# FOREST HEIGHTS ESTATES GRADING & EROSION CONTROL PLANS

FOR FOREST HEIGHTS CIRCLE  
COUNTY OF EL PASO, STATE OF COLORADO

**FOREST HEIGHTS CIRCLE  
GRADING & EROSION CONTROL PLAN**  
TITLE SHEET

Project No.: 18070  
Sheet: 1 of 4

Project No.: 18070
Sheet: 2 of 4

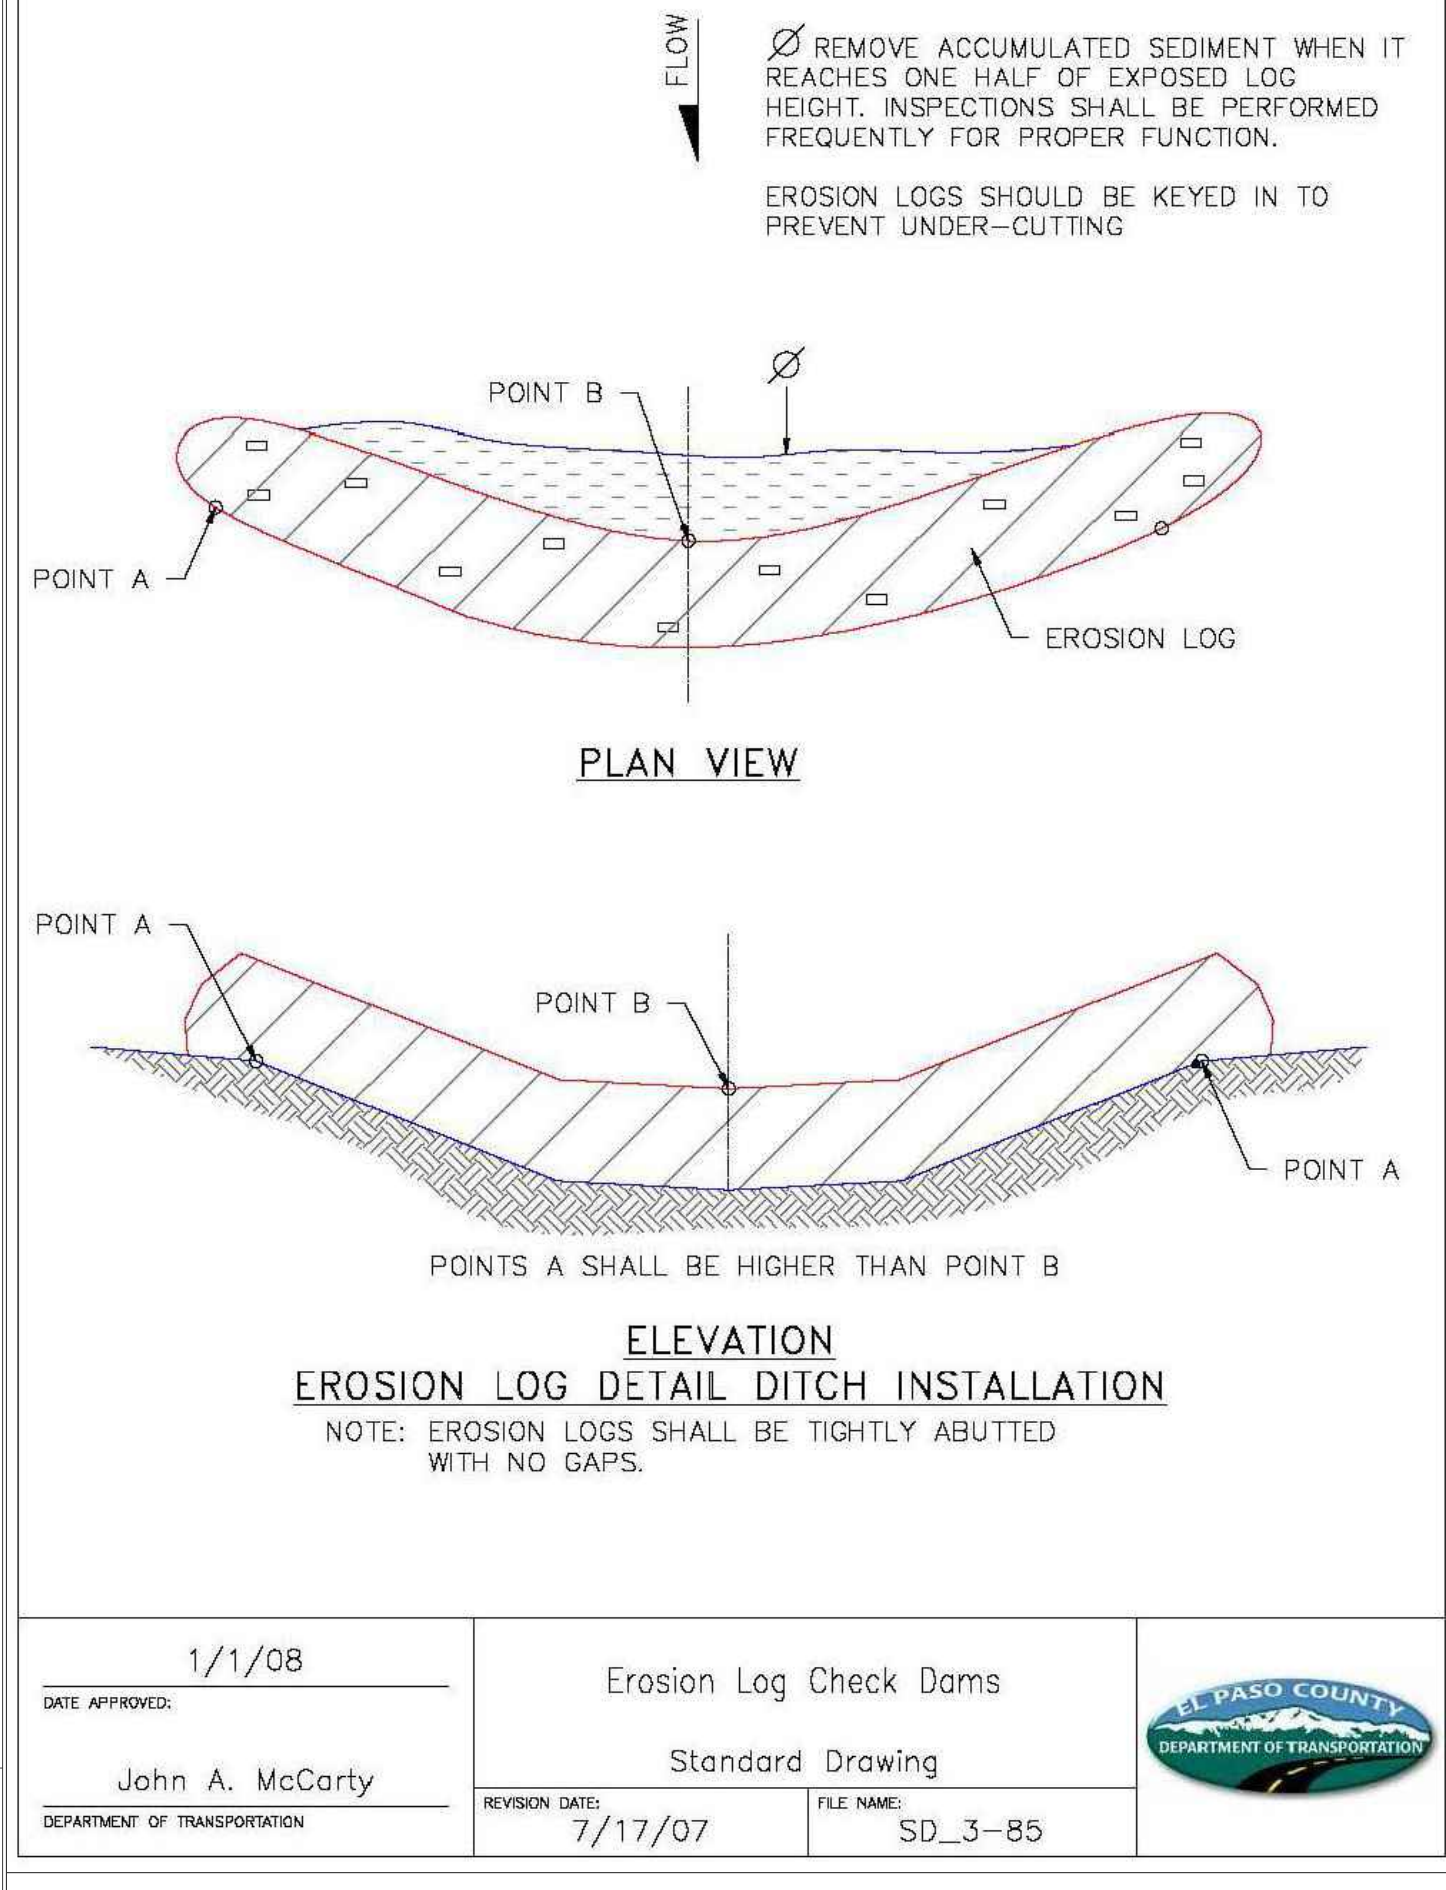
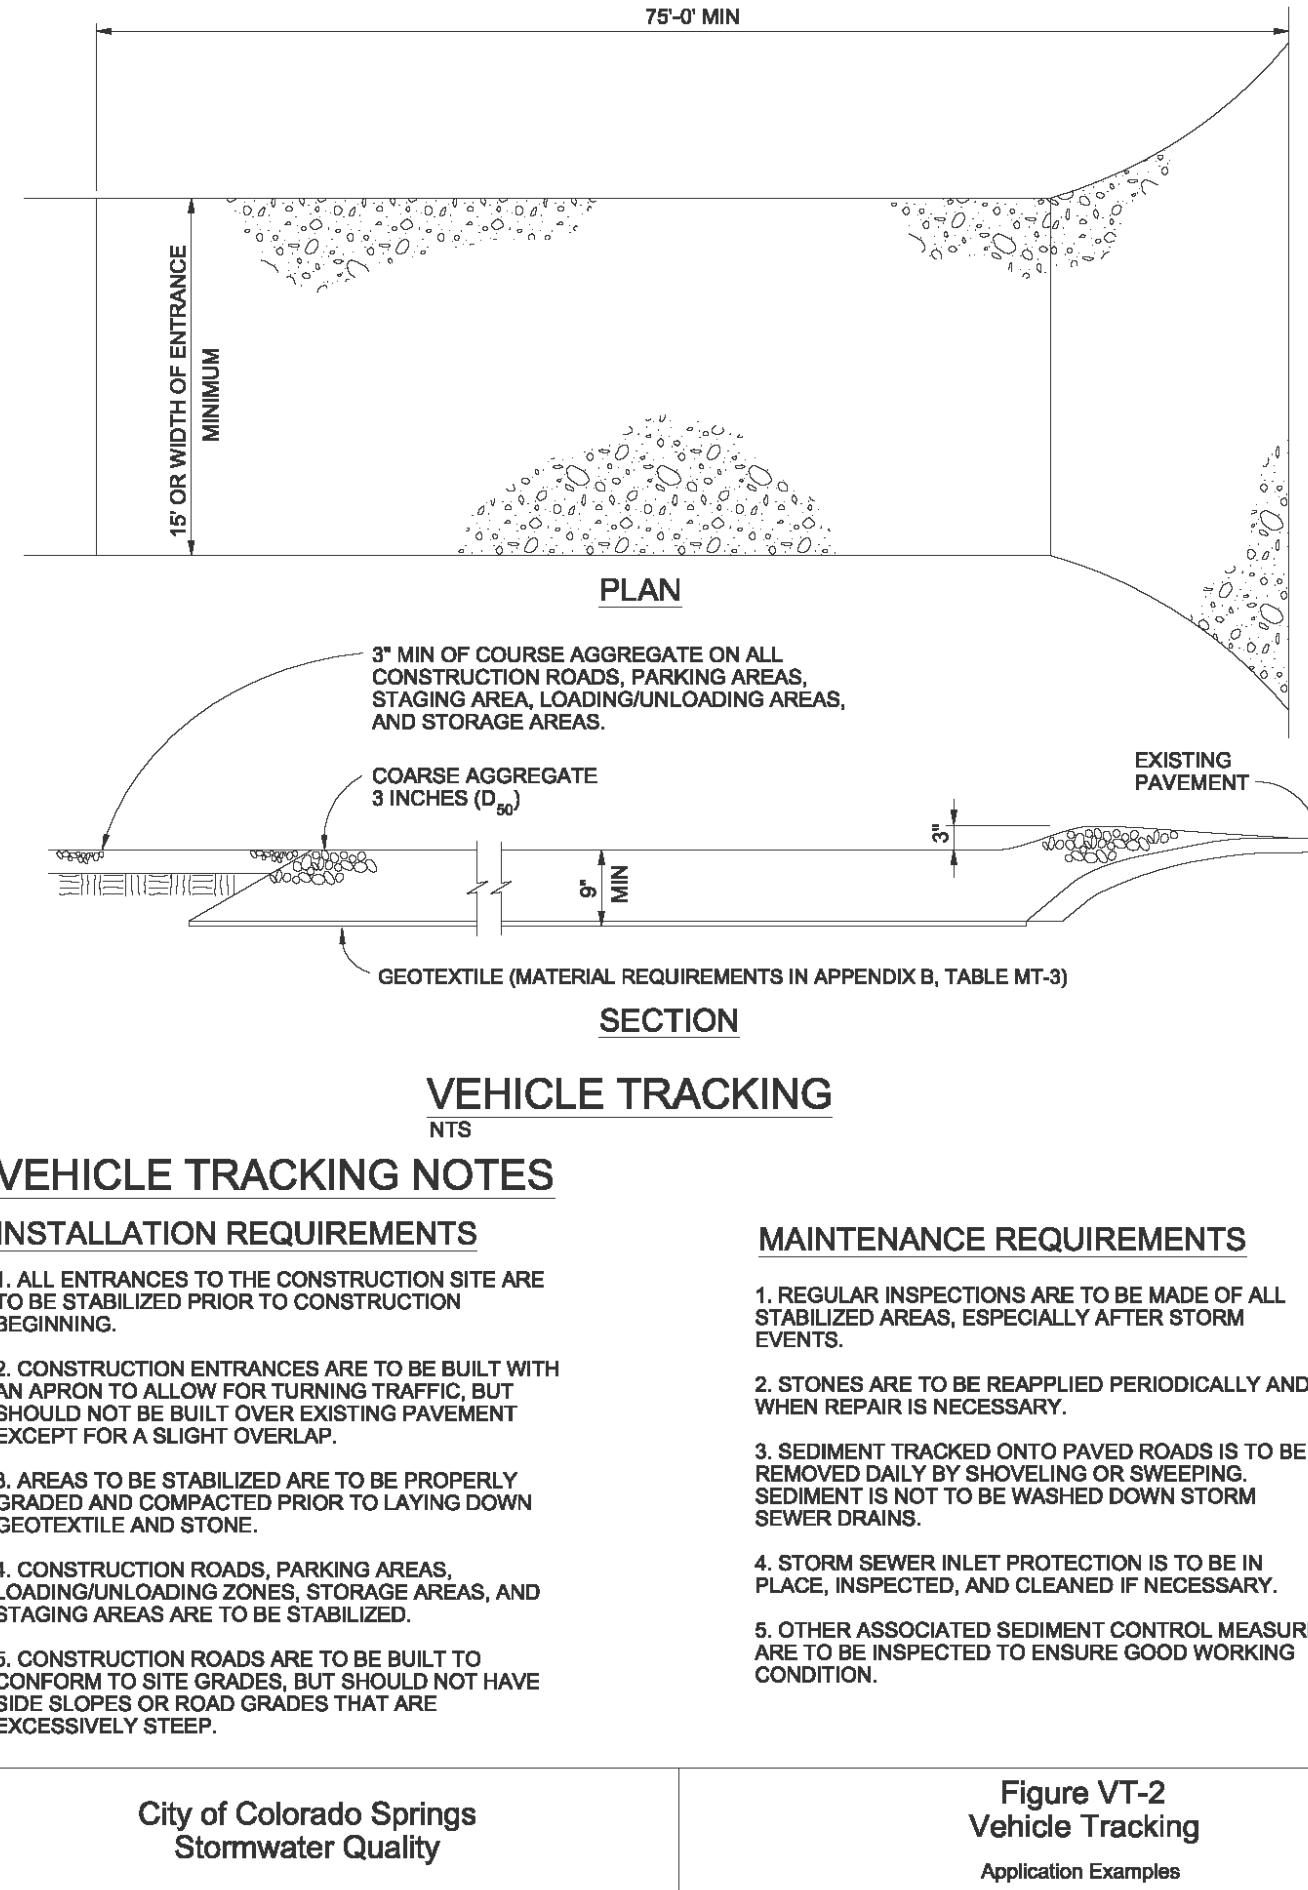
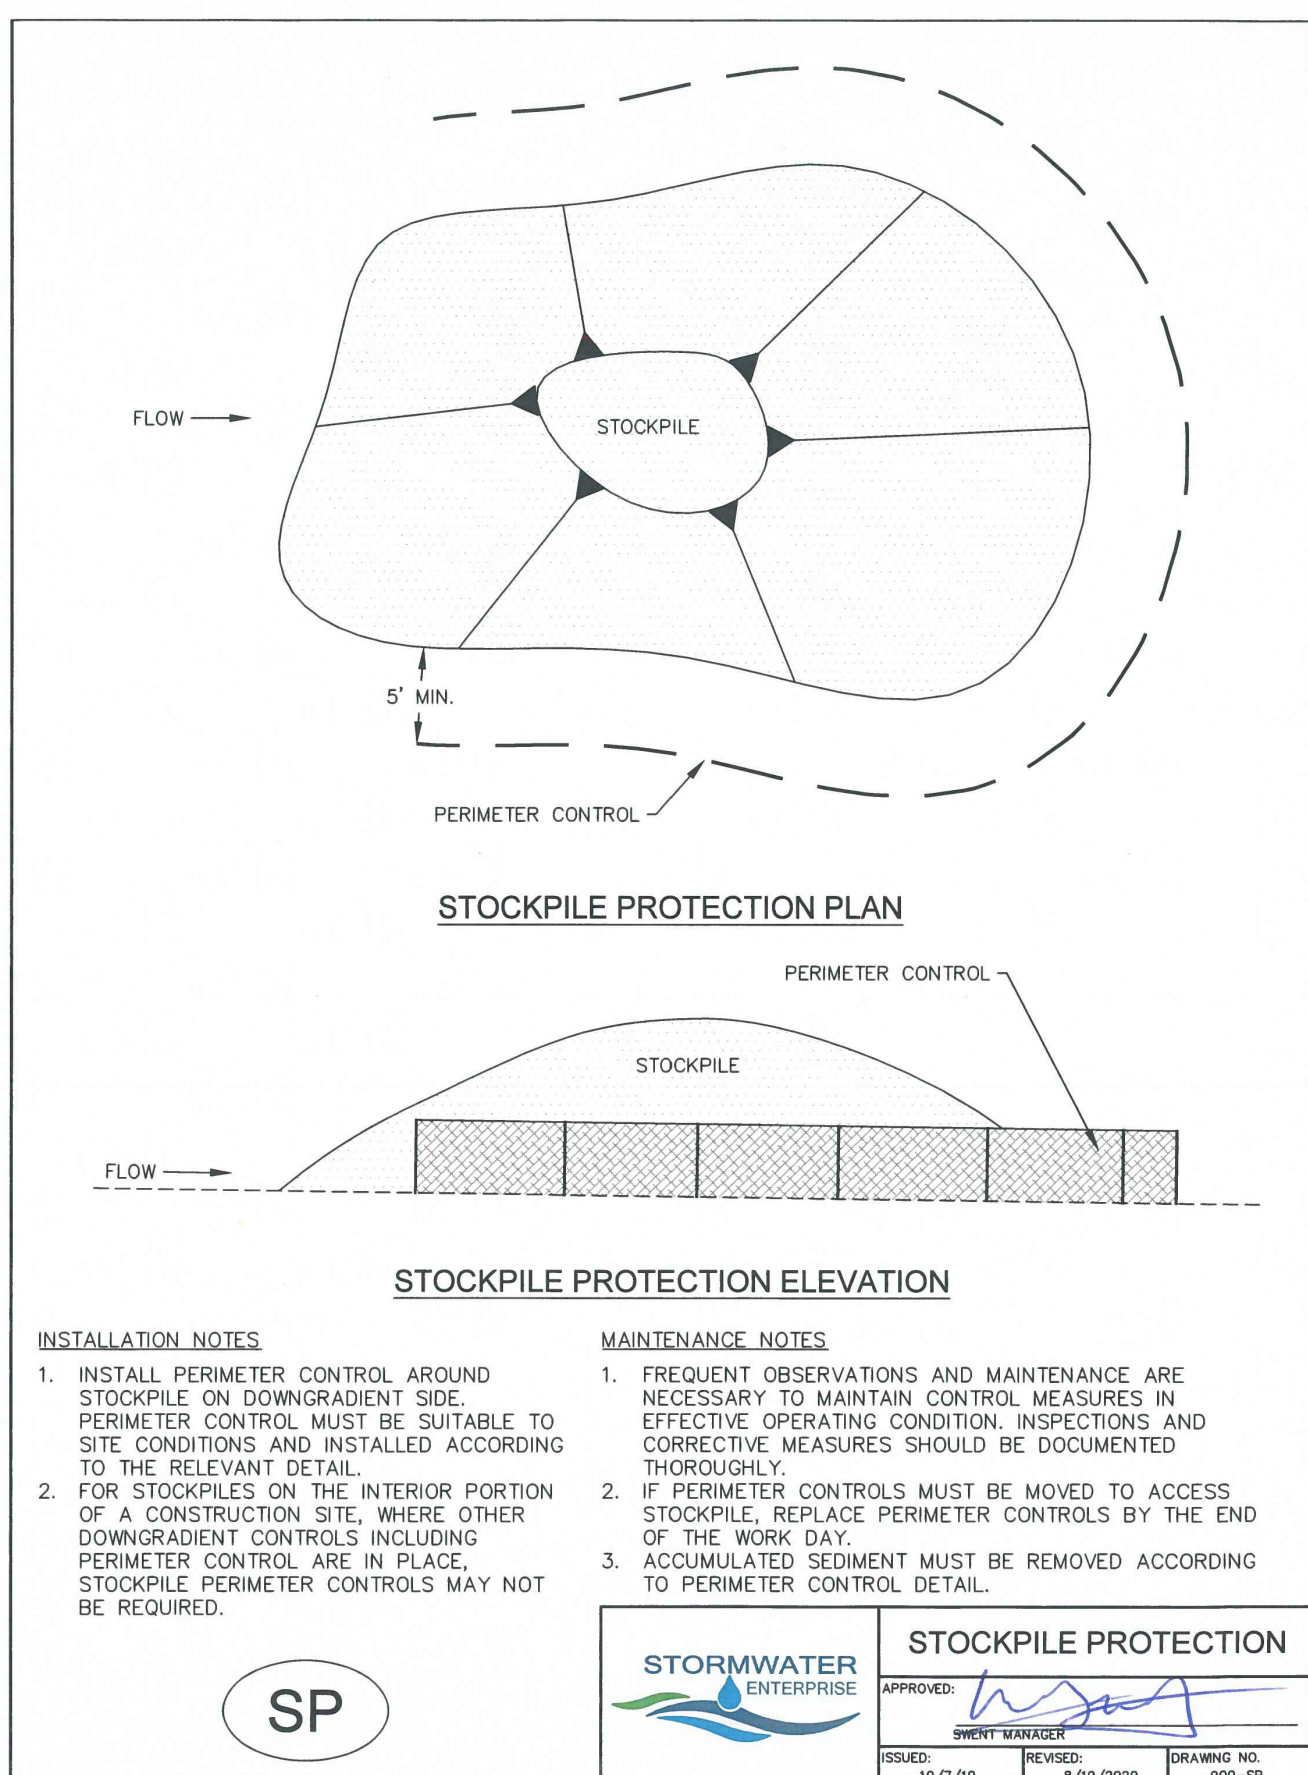
Comment generated due to changes in the document from previous submittal, per my comment on pdf pg 93 of the v3 FDR:  
It is unclear how these grass species compare to those in DCMv1 Chap 10.7, Table 10-4. Please clarify with a note here or via a discussion in the FDR what velocity and slope is permissible with these species since these are not shown on Table 10-4.

With Review #2 and #3, I asked for the VTC detail to be revised/replaced to meet our EPC criteria. With this Submittal #4, the detail was removed completely. A detail is needed since a VTC is still shown on the GEC Plan below. So please add in an acceptable VTC detail with a min 75ft length. For reference, below is my Review #3 comment:

Unresolved previous comment from Review #2:

If a VTC is added to the plans above, add a VTC detail to this sheet. And make sure to use a EPC approved VTC detail (VT-1 and VT-2 in DCMv2, Chap 3.3) or revise other detail (which usually have 50ft length) to be 75ft min length.
